To: All Staff
From: Environmental Health
Date: April 22, 2026
Subject: AU-26-00003 Campbell

SITE PLAN

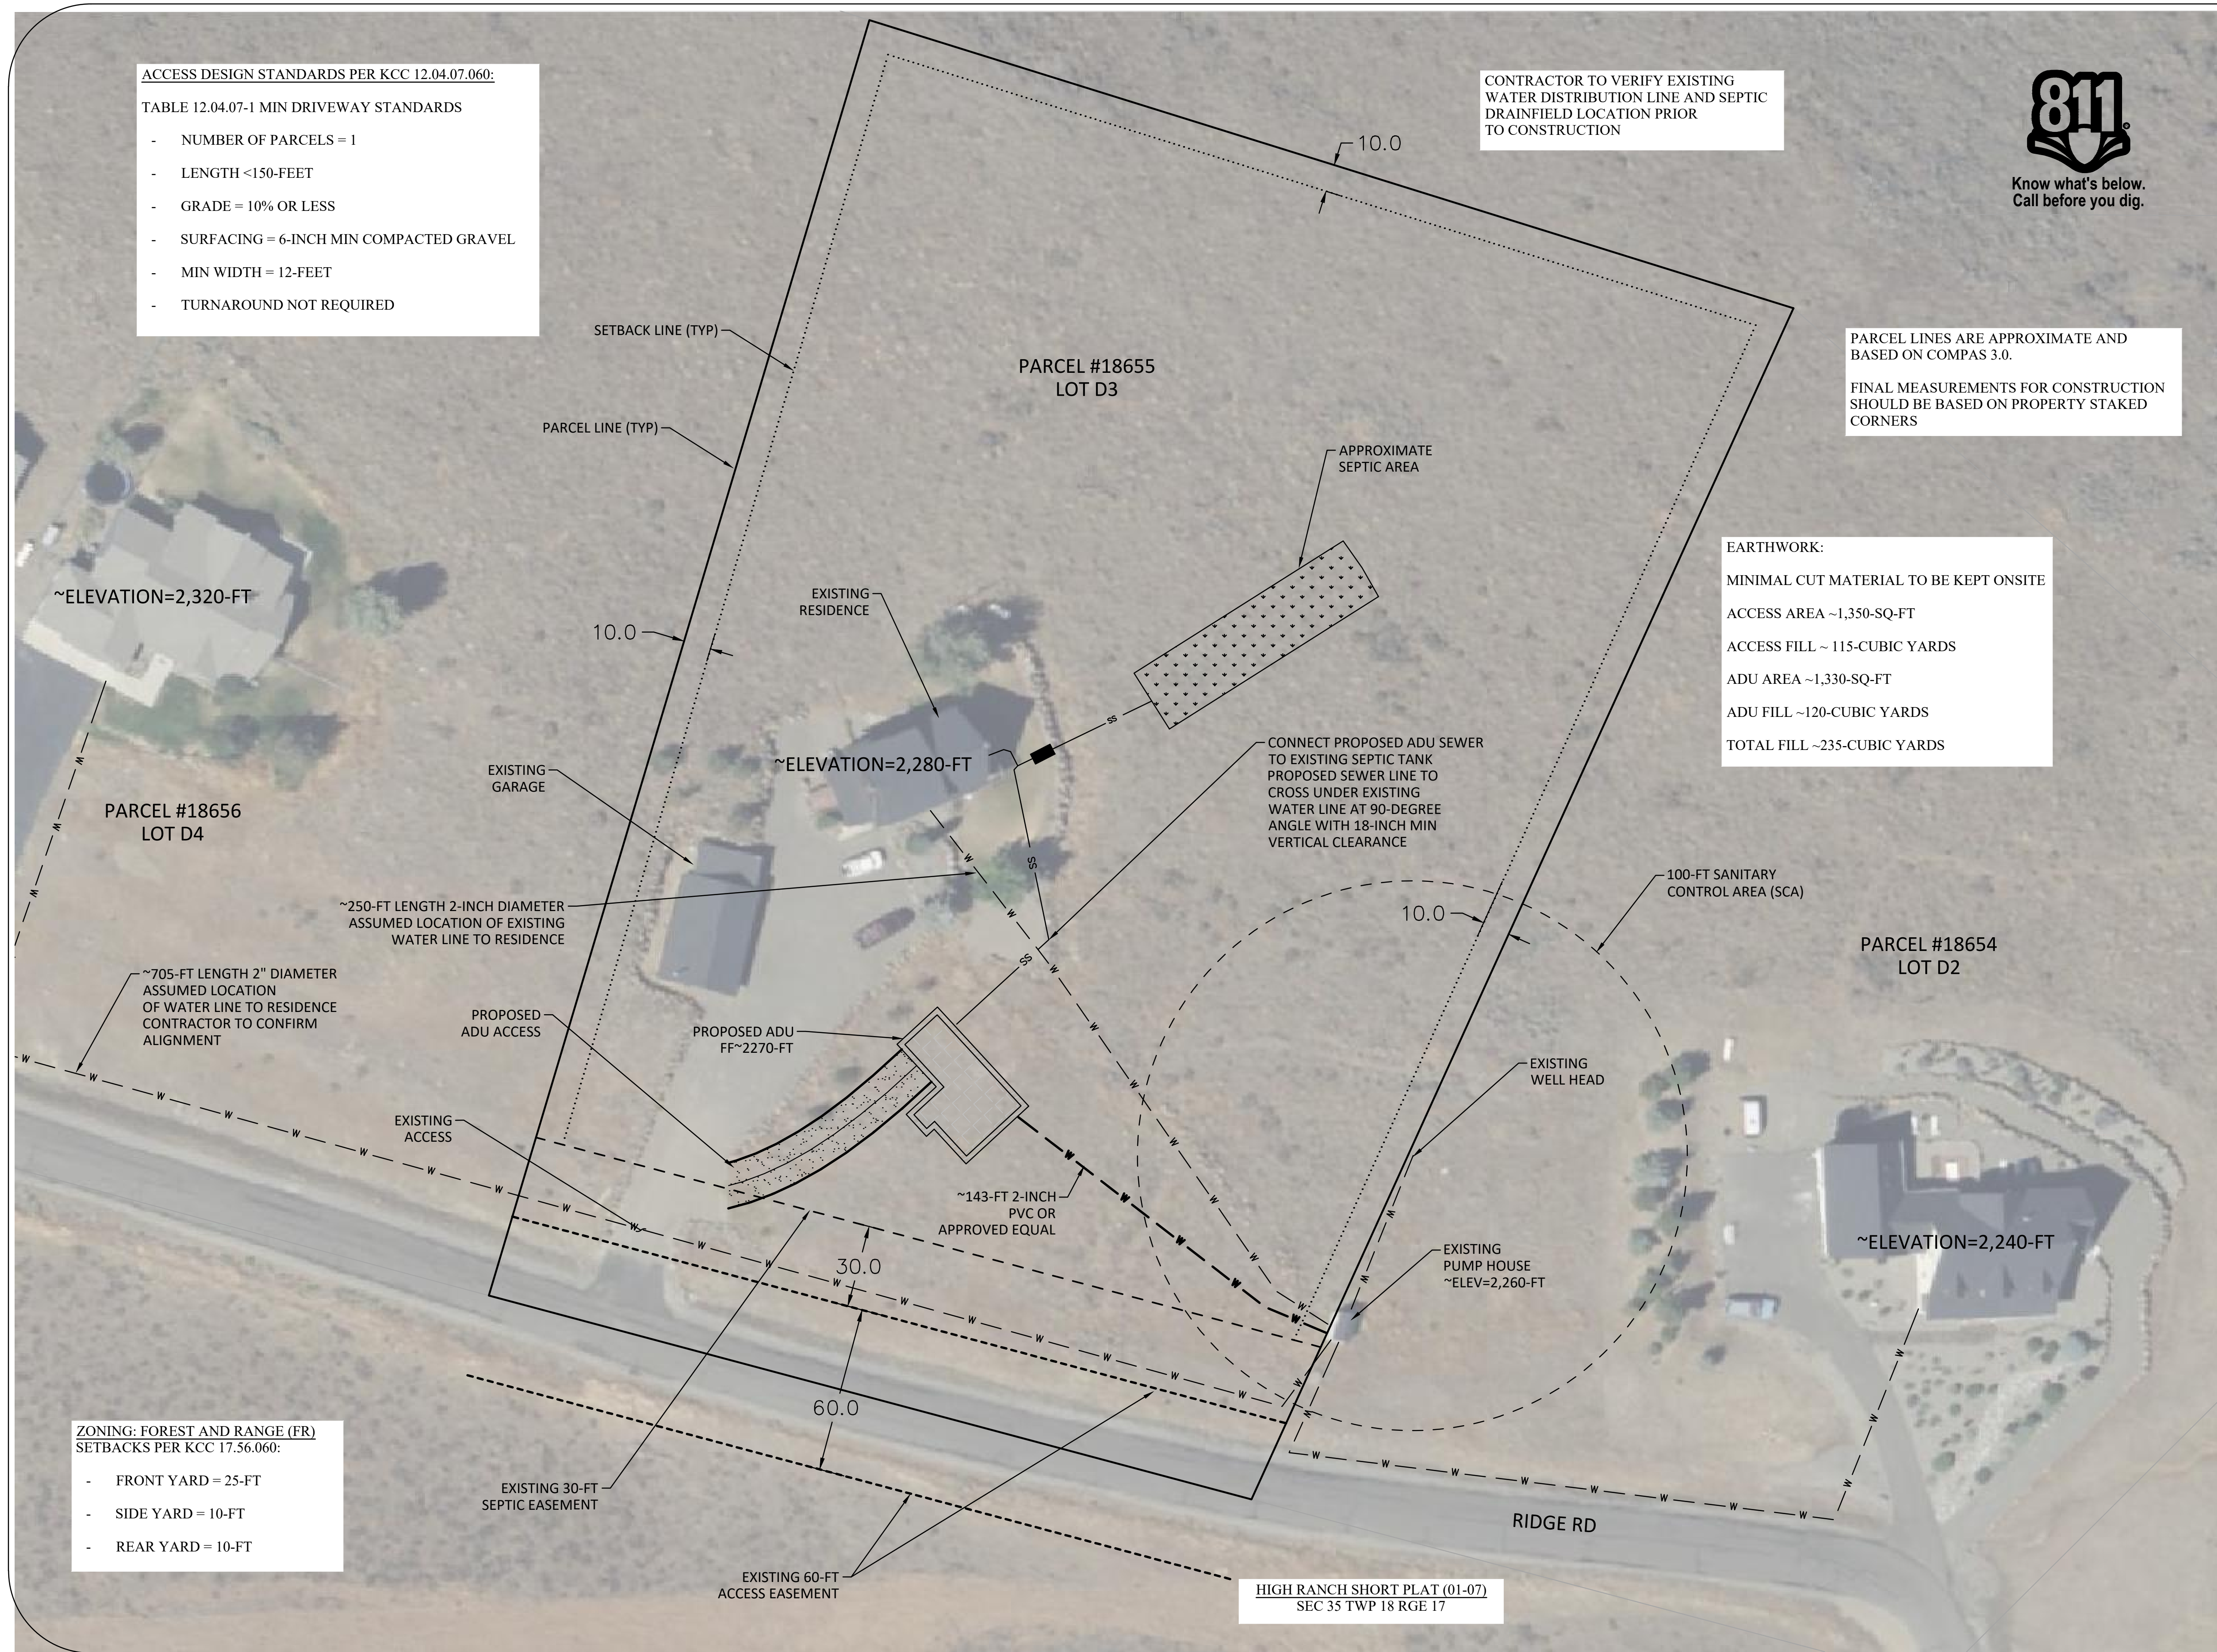
Drinking Water	• All prerequisites for the Group B expansion have been satisfied. KCPHD has no additional requirements regarding drinking water at this time.
Wastewater	• A review of the original septic design may be necessary to ensure it is sufficient for the proposed project. Please contact KCPHD with any questions regarding these requirements.
